Online Comment

Application H09-1044-23
Location Land off Hallgate & Fen Road Holbeach Spalding
Proposal Erection of 285 dwellings including parking, public open space, drainage, infrastructure, landscaping, access, appearance, layout and scale (Phase 3) - outline approval H09-0521-14 and re-submission of H09-0845-22 and H09-1118-22.

Name Priscilla Aremu
Address Housing Strategy

Date Submitted 05-04-24
For/Against Objections

PROJECT:	Proposed Residential Development at Holbeach Meadows
DRAWING:	Site Layout Phase 3 - Southern Site Plots (122 No. Plots)

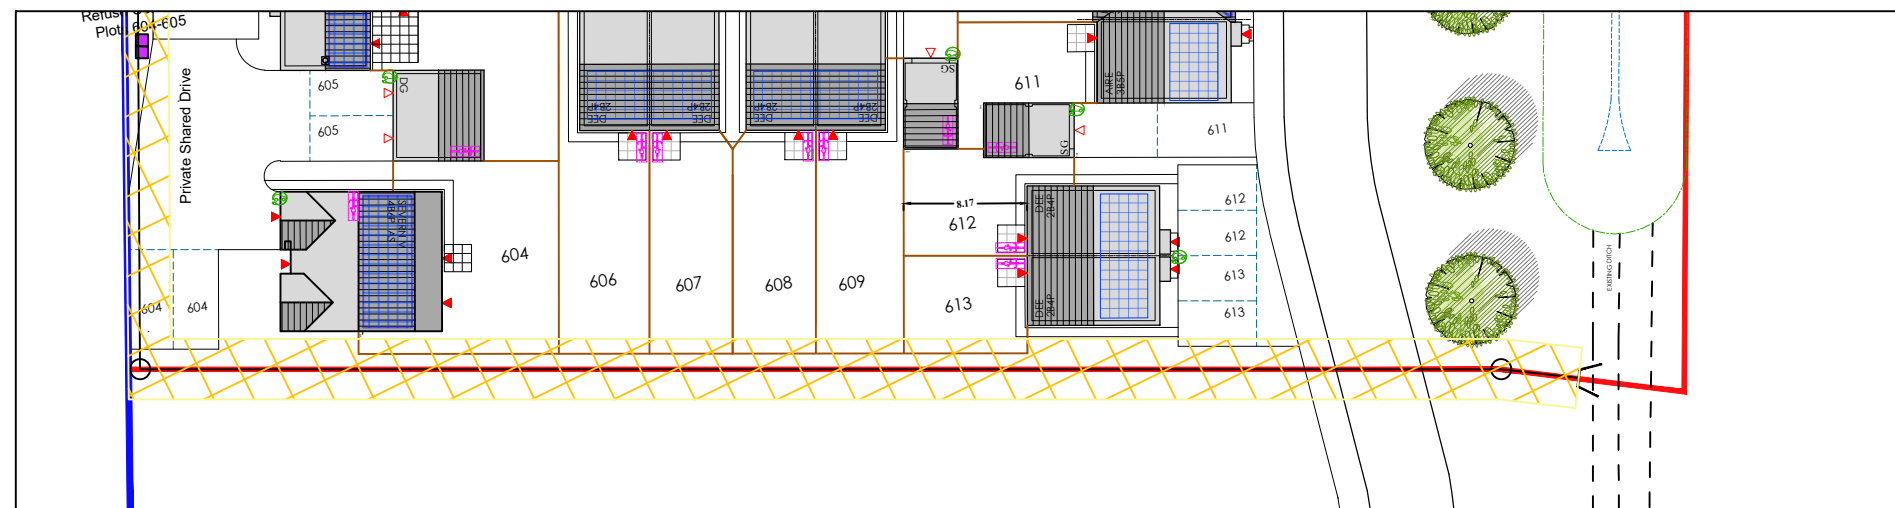
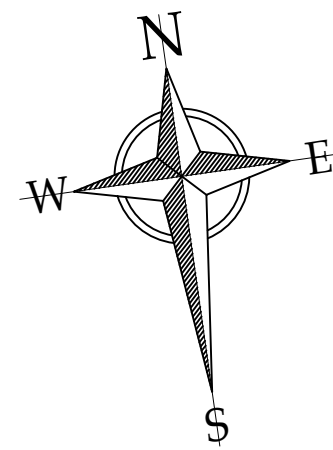
The allocation of affordable housing should be evenly distributed throughout both the Northern and Southern site plots instead of being grouped along the edges. It is recommended that affordable housing units be clustered throughout both sites for better integration. We would be grateful if the proposed layout is amended to reflect this.
